REQUEST

Current Zoning: MX-2 (mixed use district-2)
Proposed Zoning: N2-A(CD) (neighborhood 2-A, conditional)

Approximately 9.13 acres located along the north side of Interstate 485, south of University City Boulevard.

The petition proposes a residential community of up to 71 multi-family attached dwelling units.

RZ-1.0

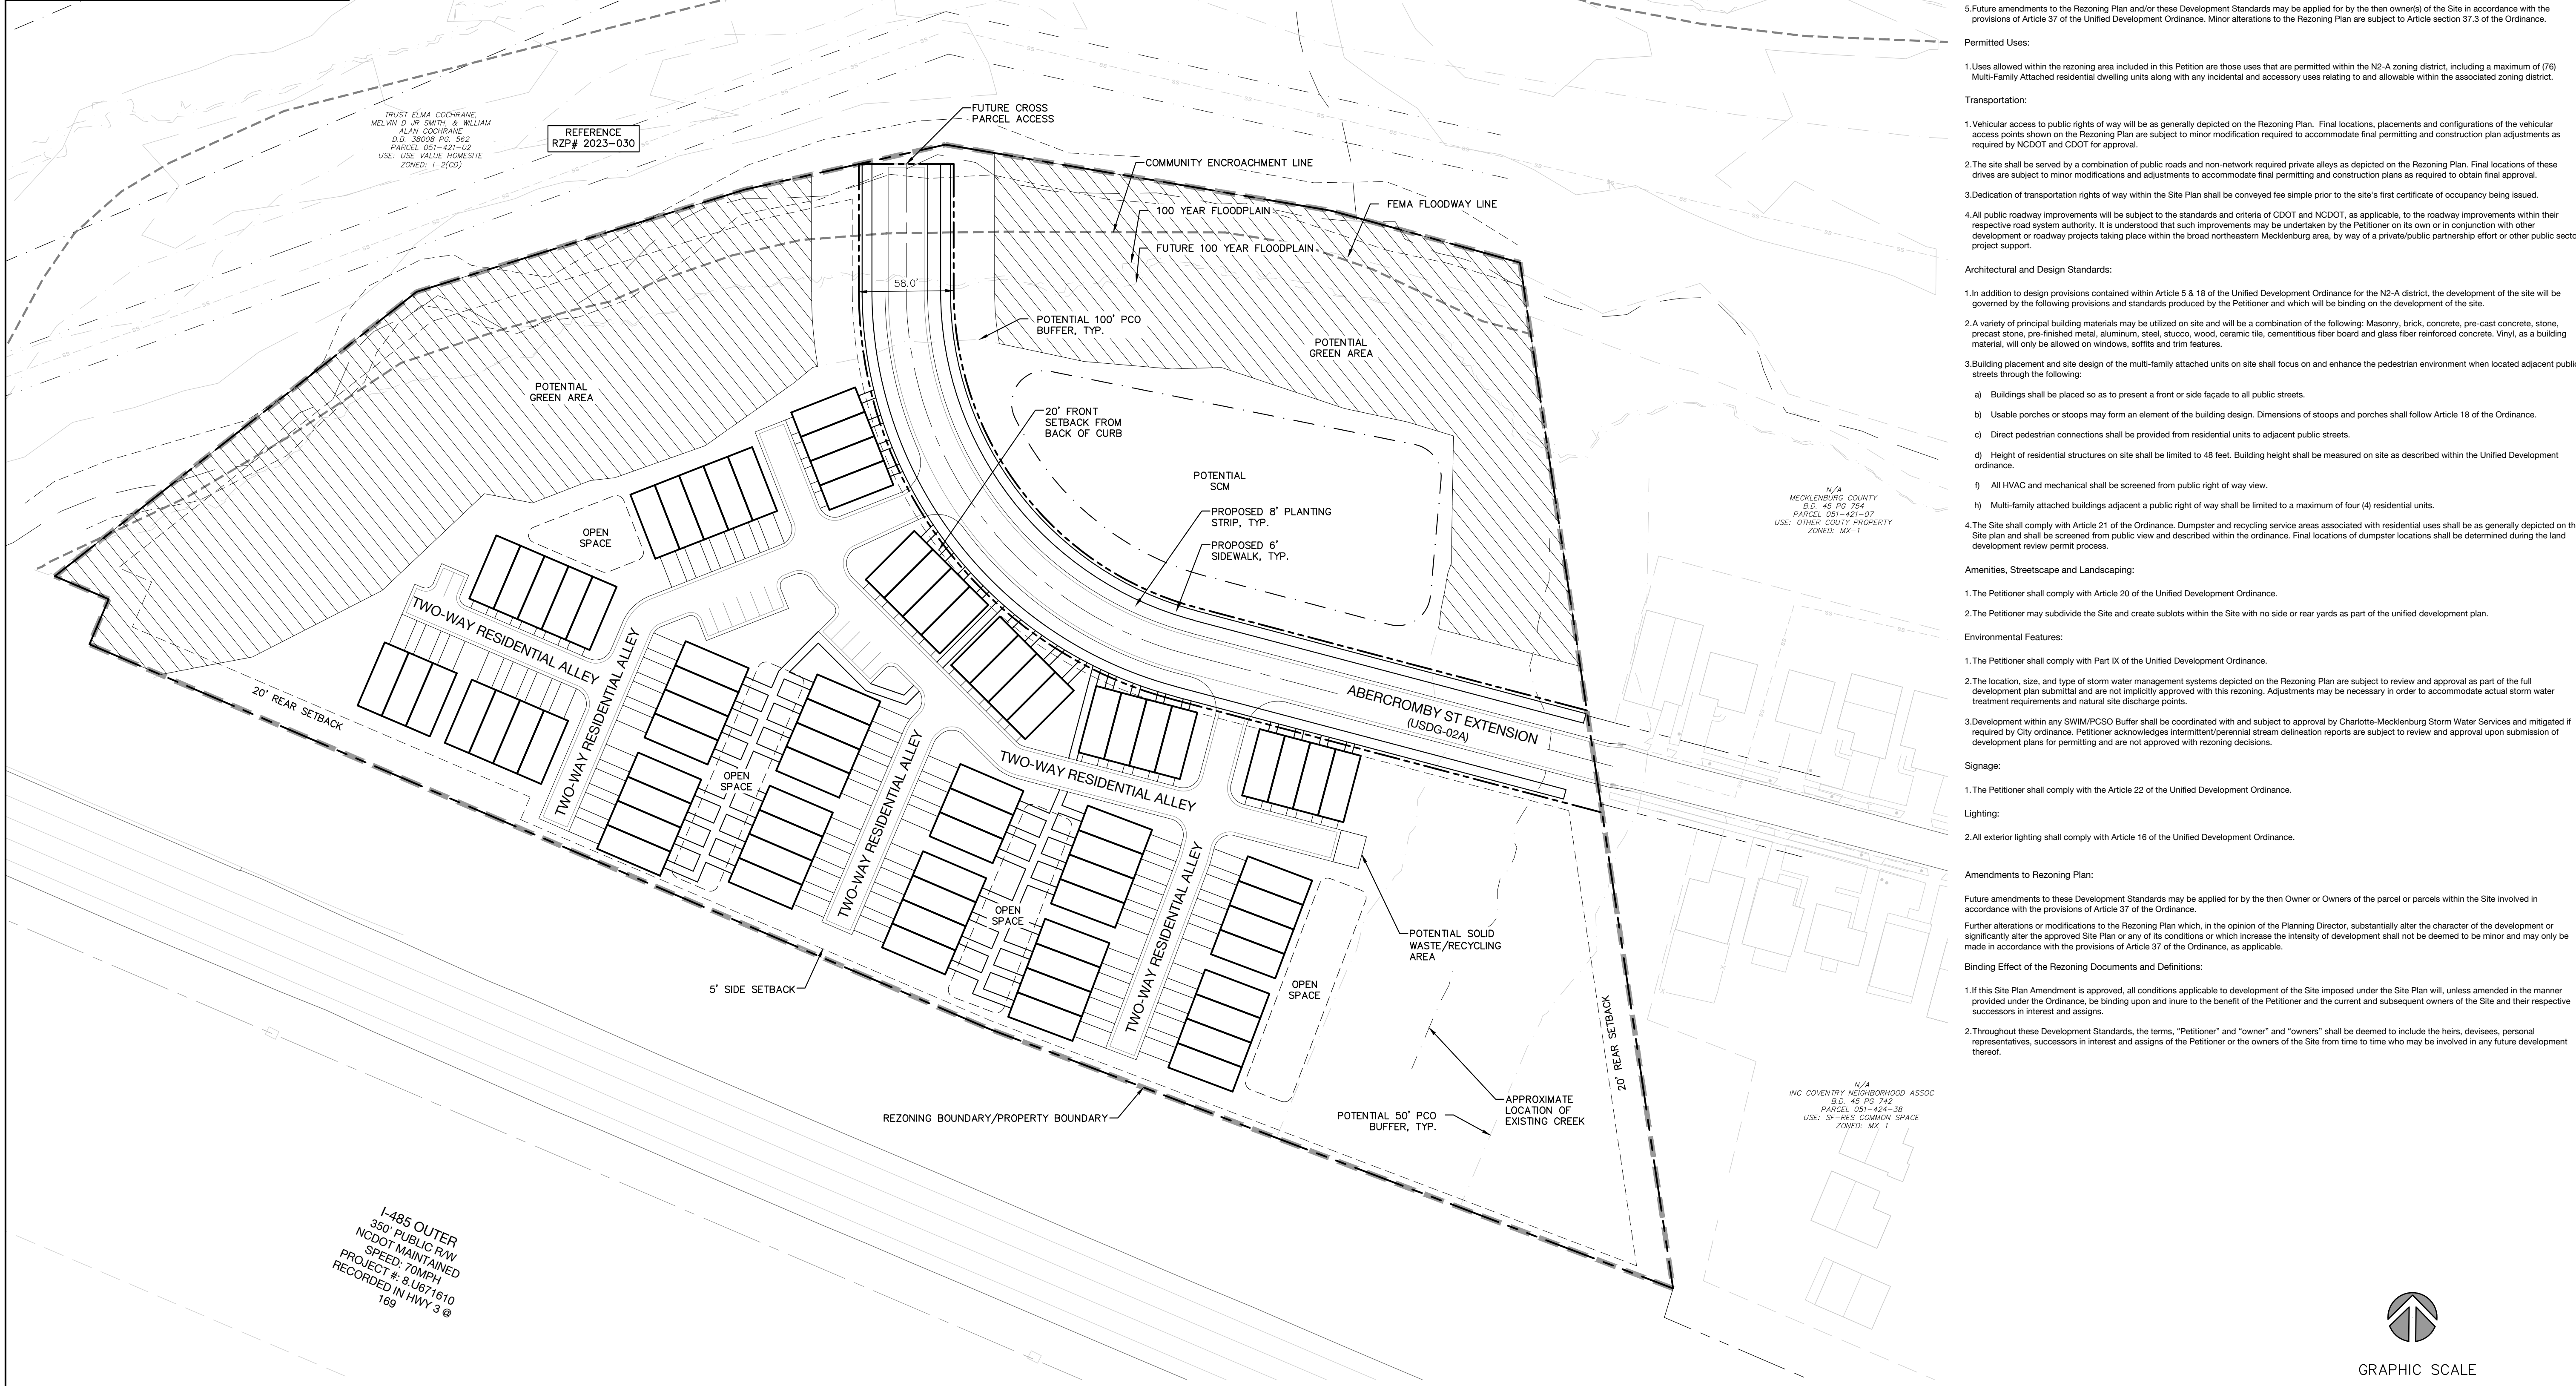
1. Roadway cross section is called out as USDG U-02. Please revise all reference to roadway standard cross section to be CLDSM U-02.

3. MCPR requests clarification of the hatched area on the current site plan. The Greenway Easement area to be dedicated and conveyed to Mecklenburg County must extend to and connect to both sides of the public ROW.
4. Tree survey required.
